CAVERSFIELD PARISH COUNCIL

7 November 2019

Caversfield Parish Council met on 6 November to consider planning application reference 19/02075/F at The Old Vicarage, Fringford Road, Caversfield, OX27 8TH with the proposal "Erection of 4 No dwelling houses with associated garages, access and landscaping".

Drawing Title:
Proposed Site Plan & Layout

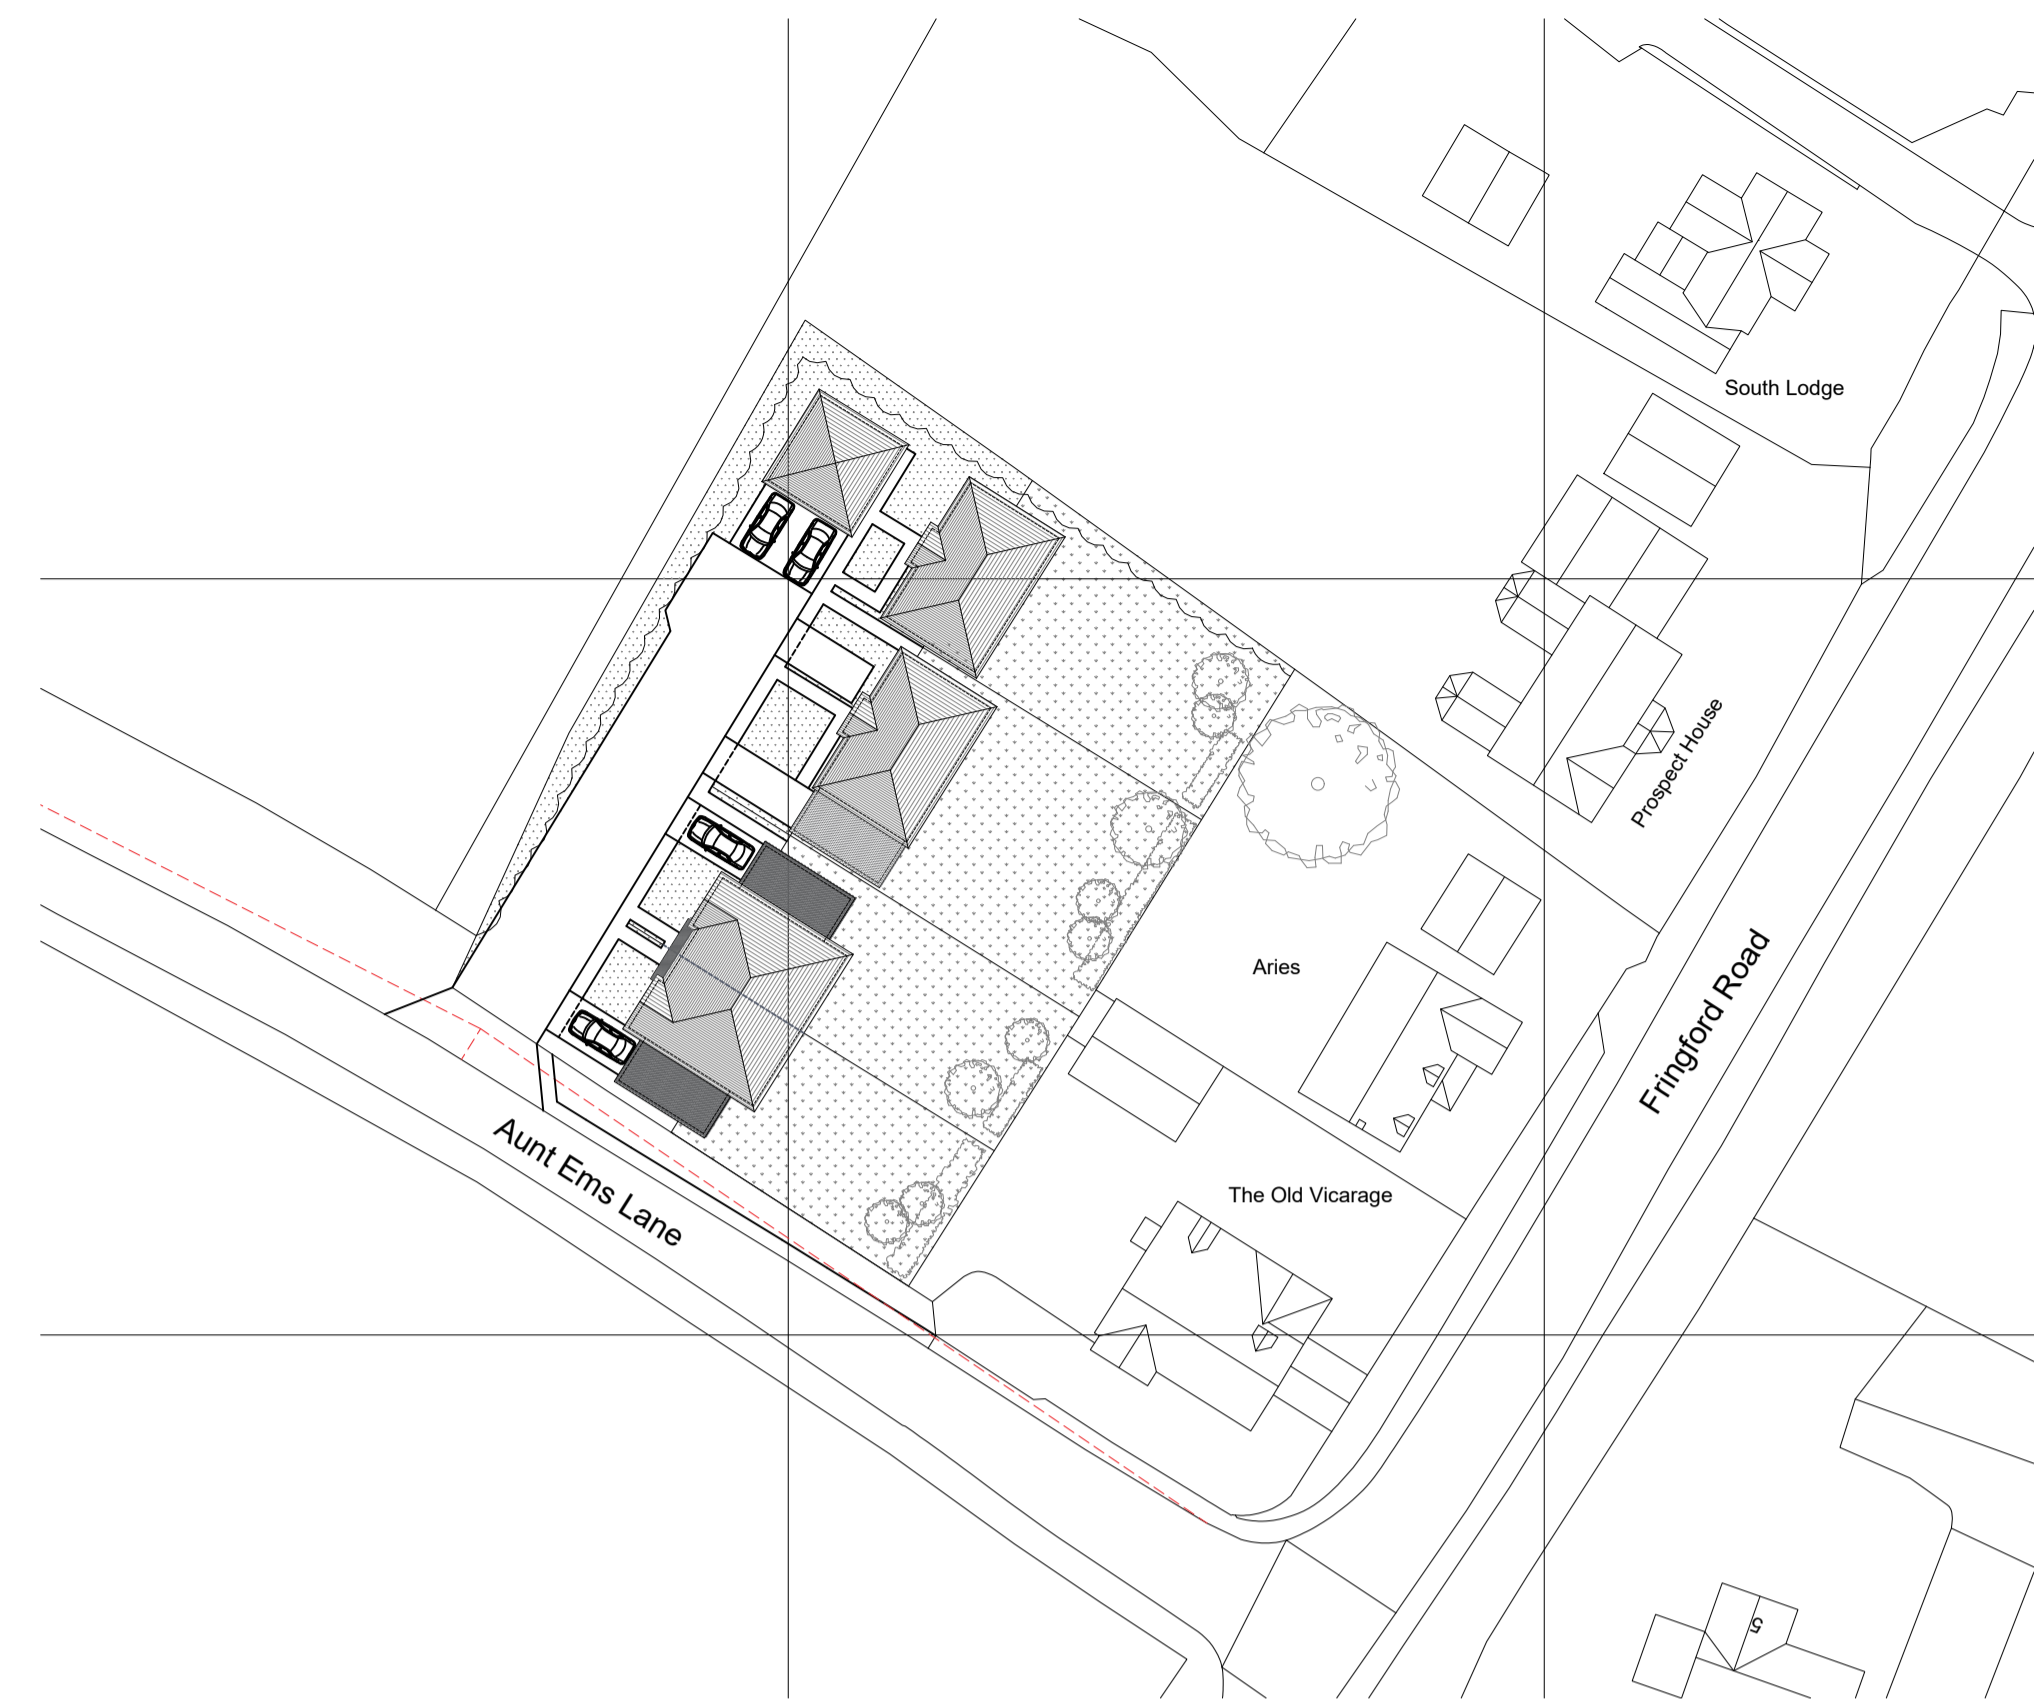
Concern was raised about the access from Aunt Em's Lane which is a National Speed Limit road of just a car and a half's width. Big vehicles such as the dustbin lorry or delivery vehicles would cause great disruption if they were permitted to stop on the road, so provision must be made to accommodate large vehicles on site.

Drawing Title:
Proposed Street Elevations

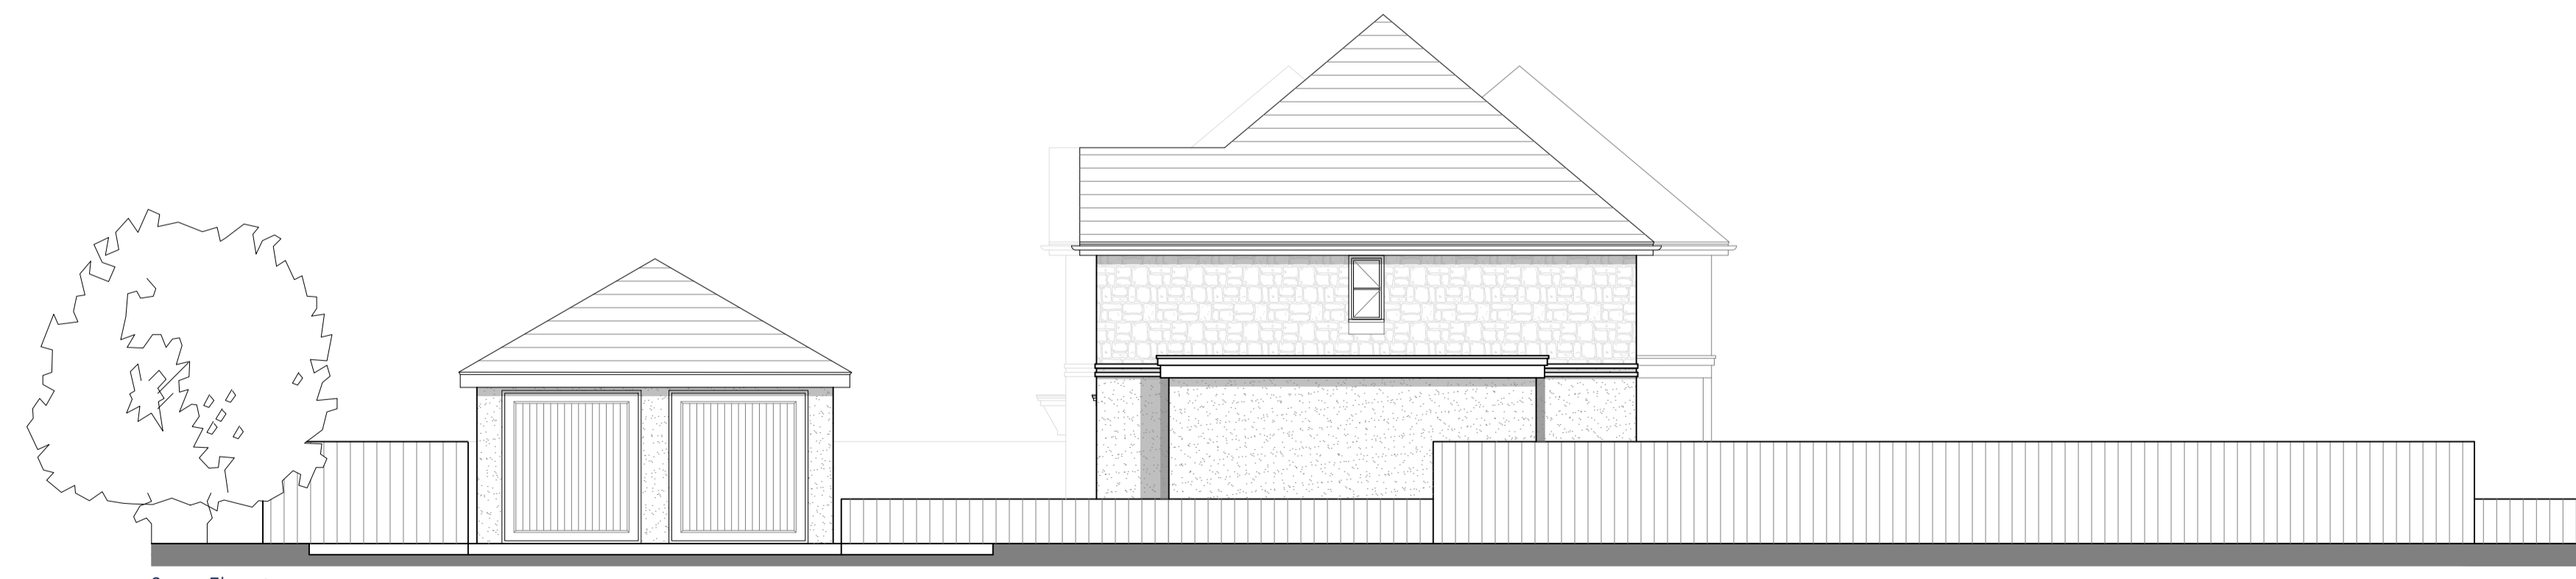
Considering the street scene, the four houses will appear incongruous and out of place in the context of what was probably the paddock for the Vicarage (which was formally connected with the Grade II* Listed 10th / 12th Century Church). The stone and white render and blue clay roof tiles may complement the Vicarage, but no other houses in the vicinity have this appearance.
